TAG PEER REVIEW- HODDER BRIDGE, CLITHEROE, 21 JUNE, 2021

James Ellis, Director at Rural Solutions and planning consultant for the owners, invited the Traditional Architecture Group Peer Review Panel to assist in commentary on proposals for a new house at Hodder Bridge, Clitheroe. The Peer review follows pre-application consultation the applicant has undertaken with the local authority.

An application is to be made as an NPPF clause 79e application.

MAIN HOUSE GROUND FLOOR PLAN_AS PROPOSED 1:100 @ A3

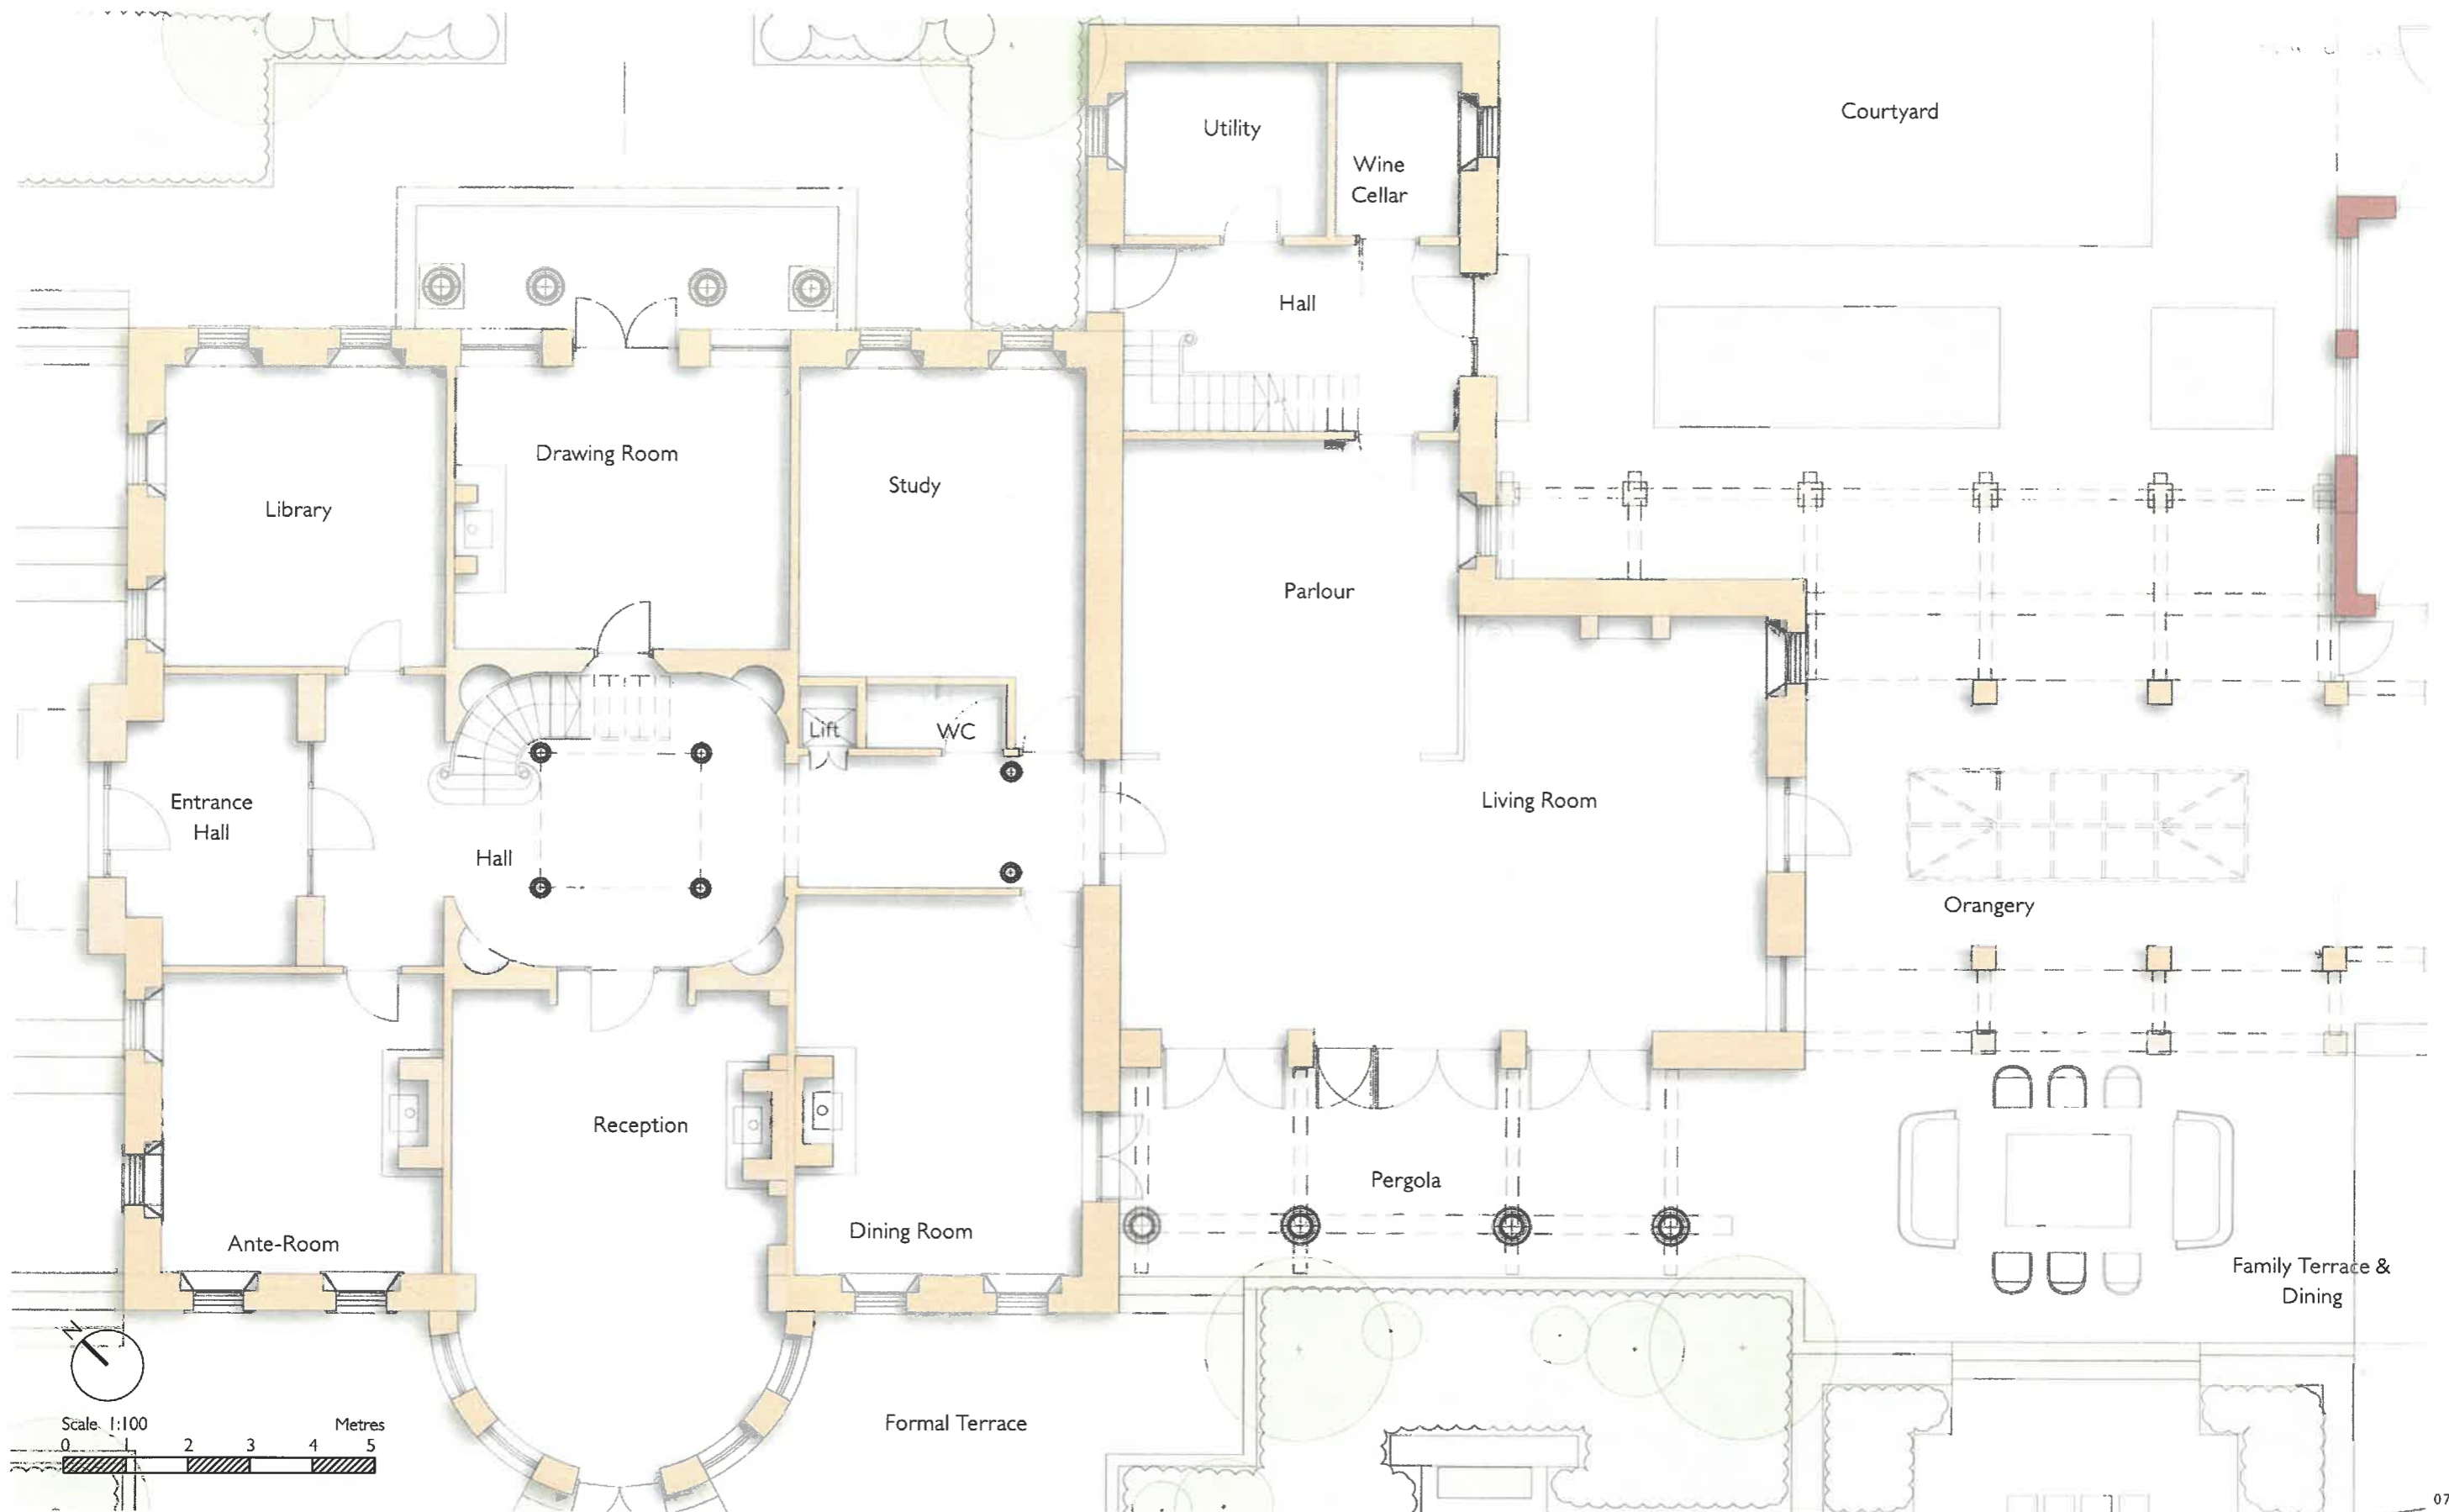
- Emphasis was placed on the axial arrangement running west to east through the building. The central stairs interrupts this, some further consideration of that sequence and the function of the stairs in the spatial arrangement should be considered;
- Lanterns and roof lights perhaps could be much less evident. In the reality of viewing a building form ground level nearer the buildings it is understood that they likely will not be seen from the ground however there are vantage points where the roofscape might be seen from above, a fifth elevation to consider!

NORTH WEST ELEVATIONS_AS PROPOSED 1:500 & 1:125 @ A3

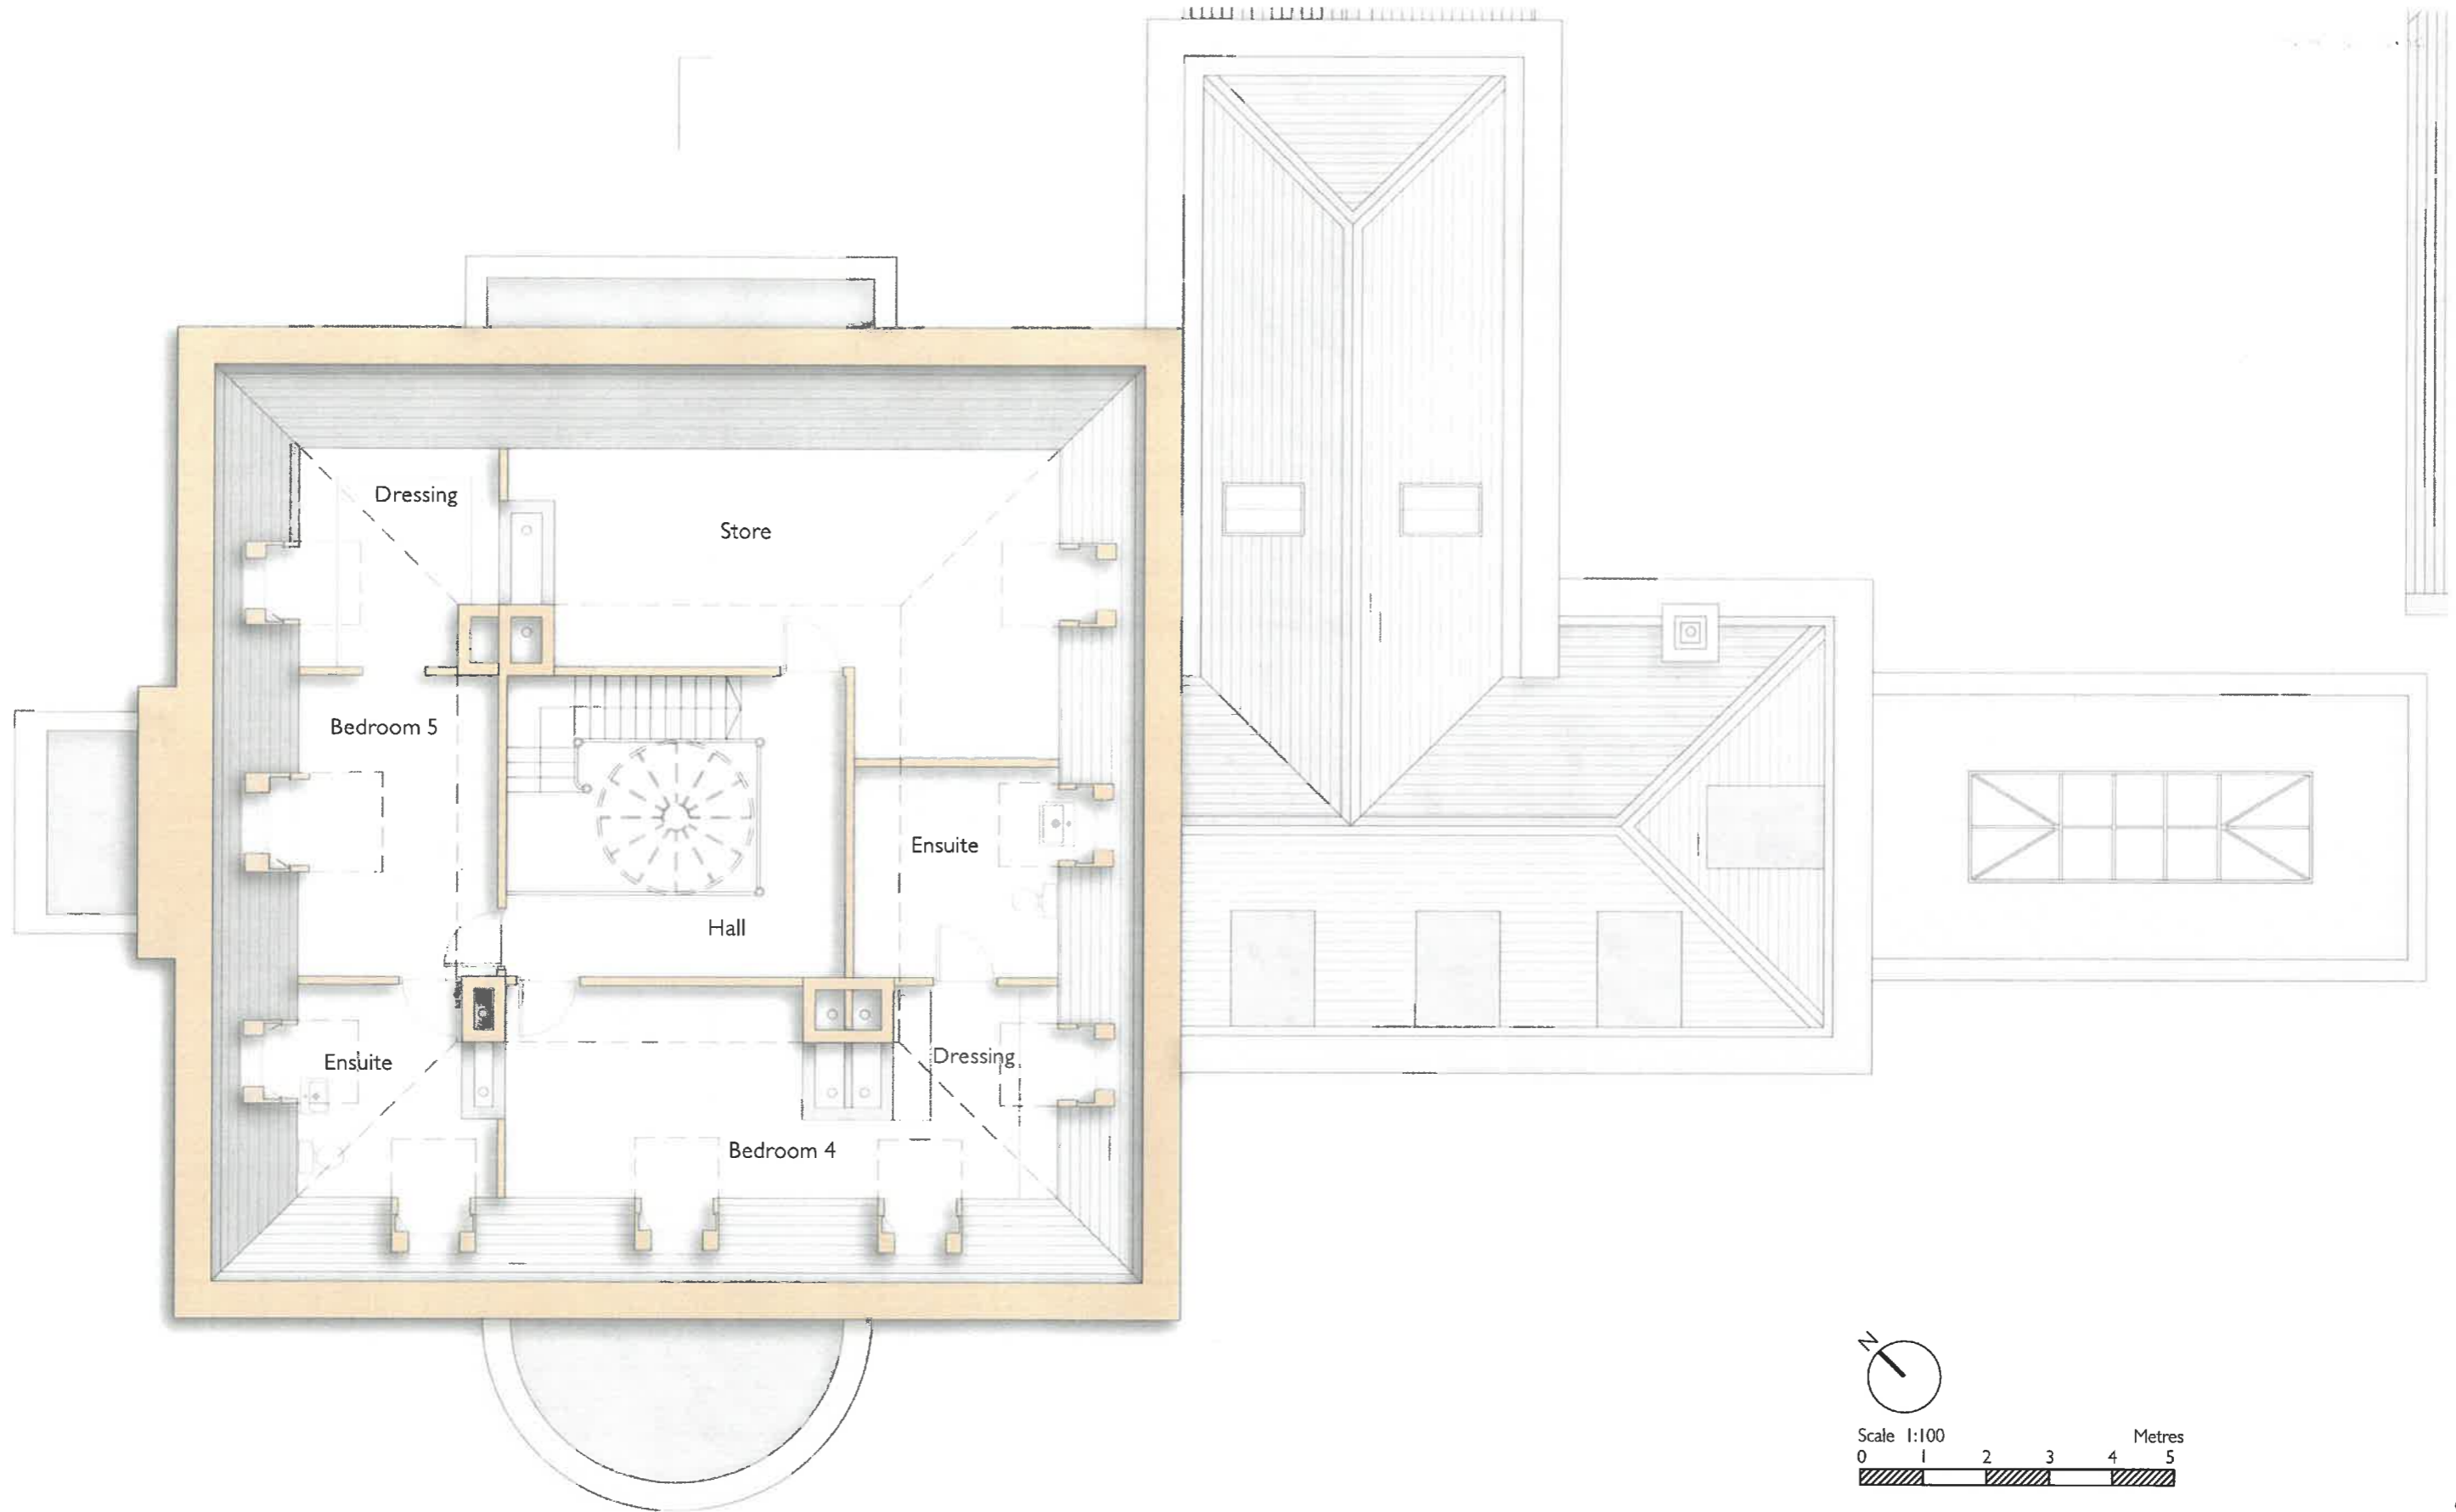
- The north-west entrance composition of front porch, tri-partite window with bracketed cornice feature and dormer above- The Panel's comments were that those elements could work better together if strengthened in a more comprehensive composition, the dormer and tri-partite window being perhaps too weak in the vertical hierarchy of the main entrance elevation. The side lights to the tri-partite window too narrow and out of proportion with the other glazing pains. It may be a pediment over this window reaching up into the parapet cornice would assist. The porch is too deep as seen from the south-west;

Tripartite Window 1:20

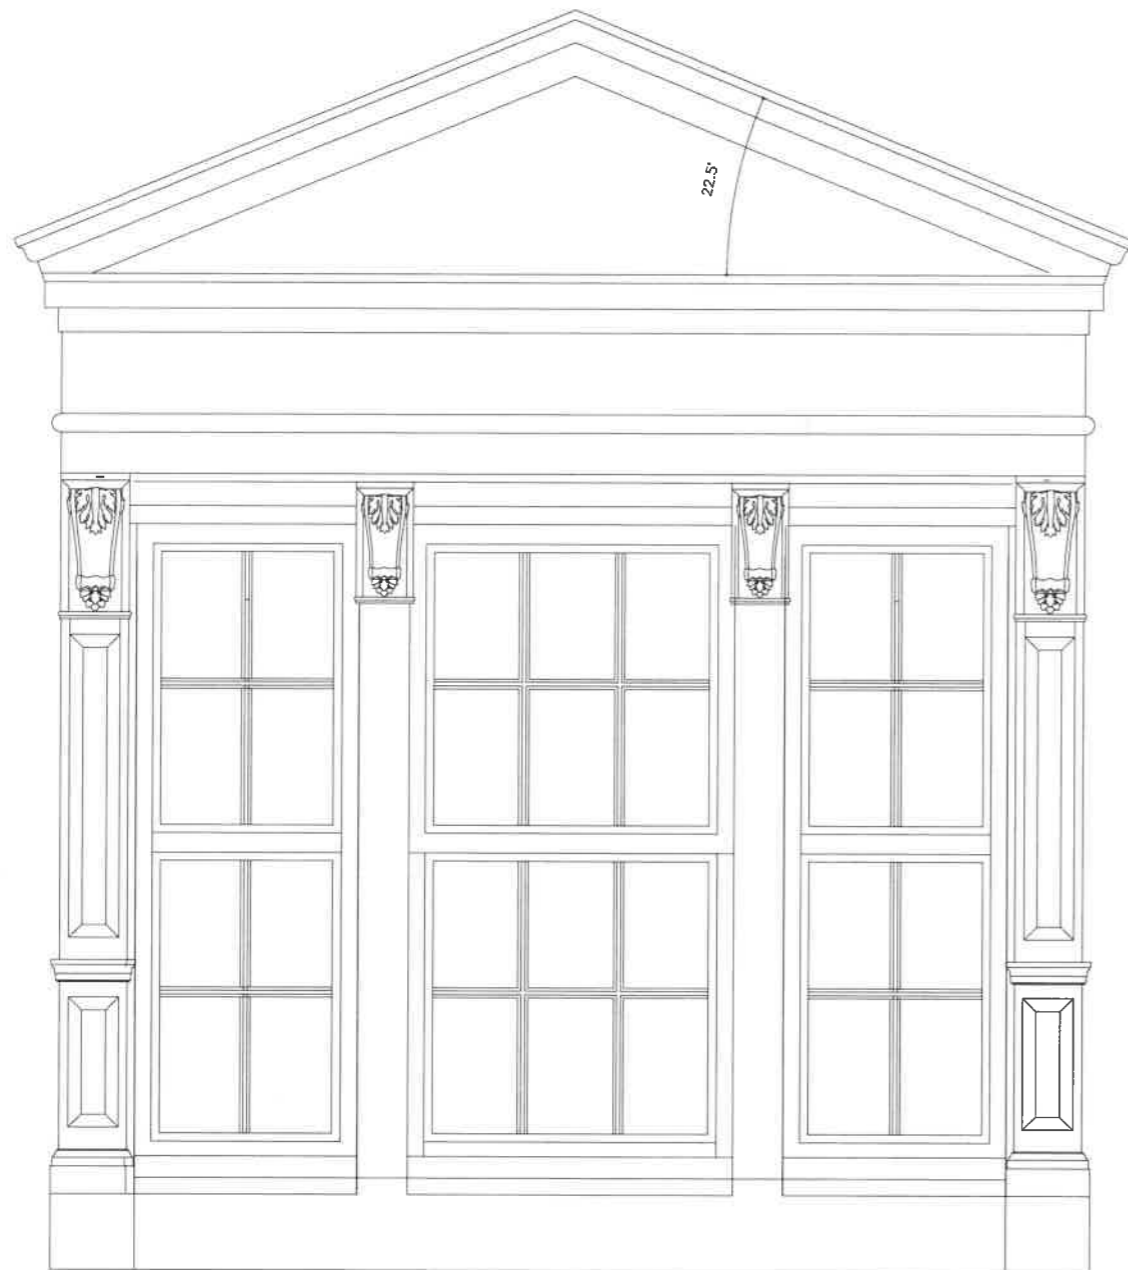
- The south-east elevation of the house itself seems to work well. The tripartite window form is repeated on the first floor, again this is weak and also needs some further work;

Ionic Order Stone Column 1:20

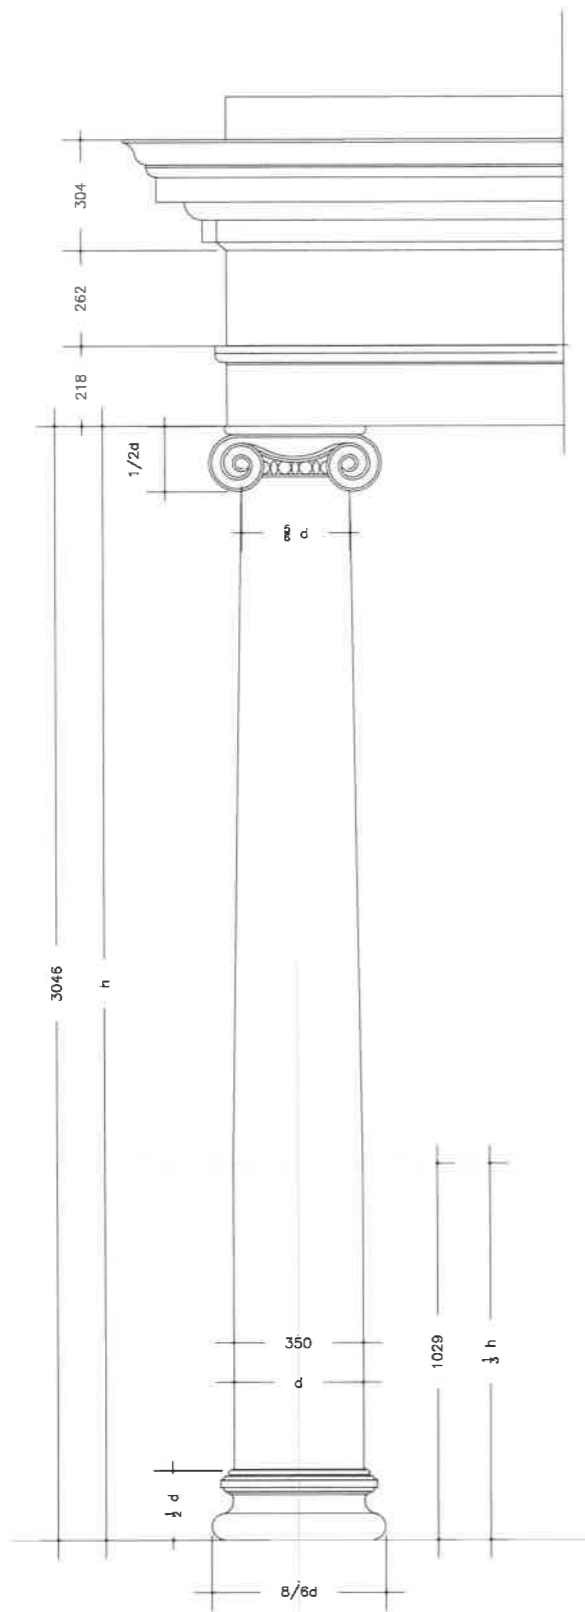
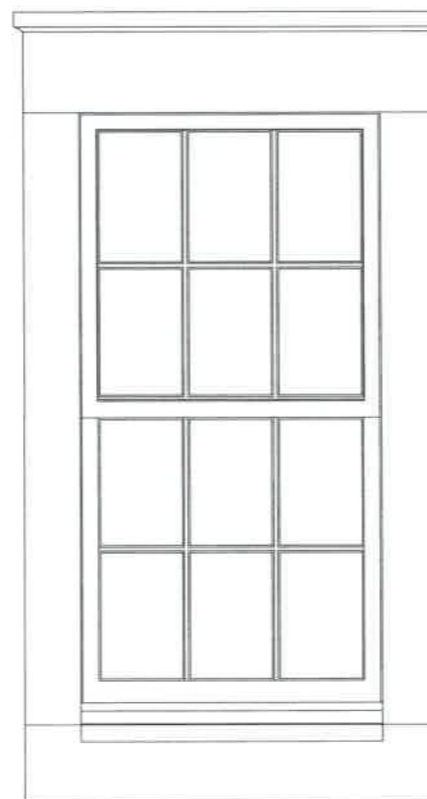
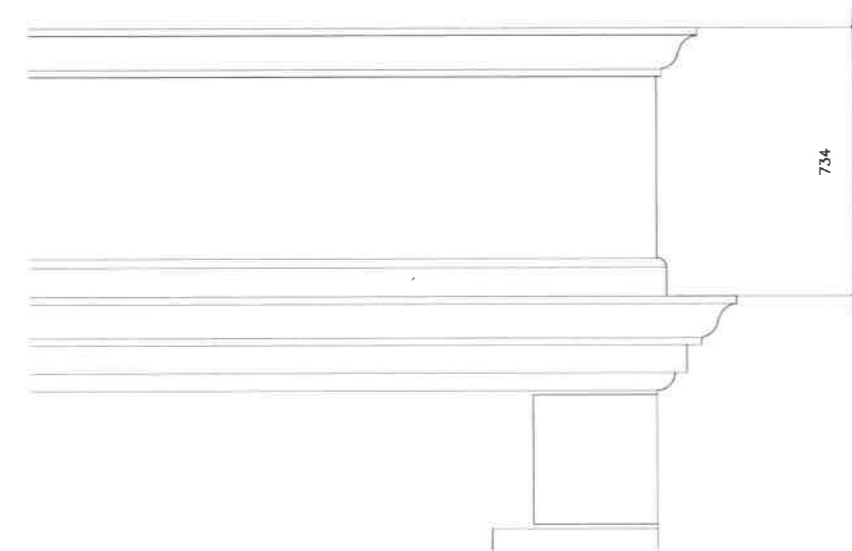
- Detailing of columns, cornices, surrounds, quoins and parapets should all follow the general rules of classical detailing. Some of the detail illustrated is not correct. If this is to be a truly exceptional piece of work those aspects of the scheme need to be worked out fully. Maybe the details could be simpler and more robust, less fussy, some aspects taken from local examples and the vernacular building detailing. The building will then speak fully to both design and crafting of a building set in tradition and context yet built for today. The skills and craft necessary to execute the stonework alone should be a significant consideration in establishing the exceptional qualities of the proposal. The detailing both of the classical forms and that concerning the Passivehaus compliance should be part of any application to show the intentions of the proposals can be realistically executed;
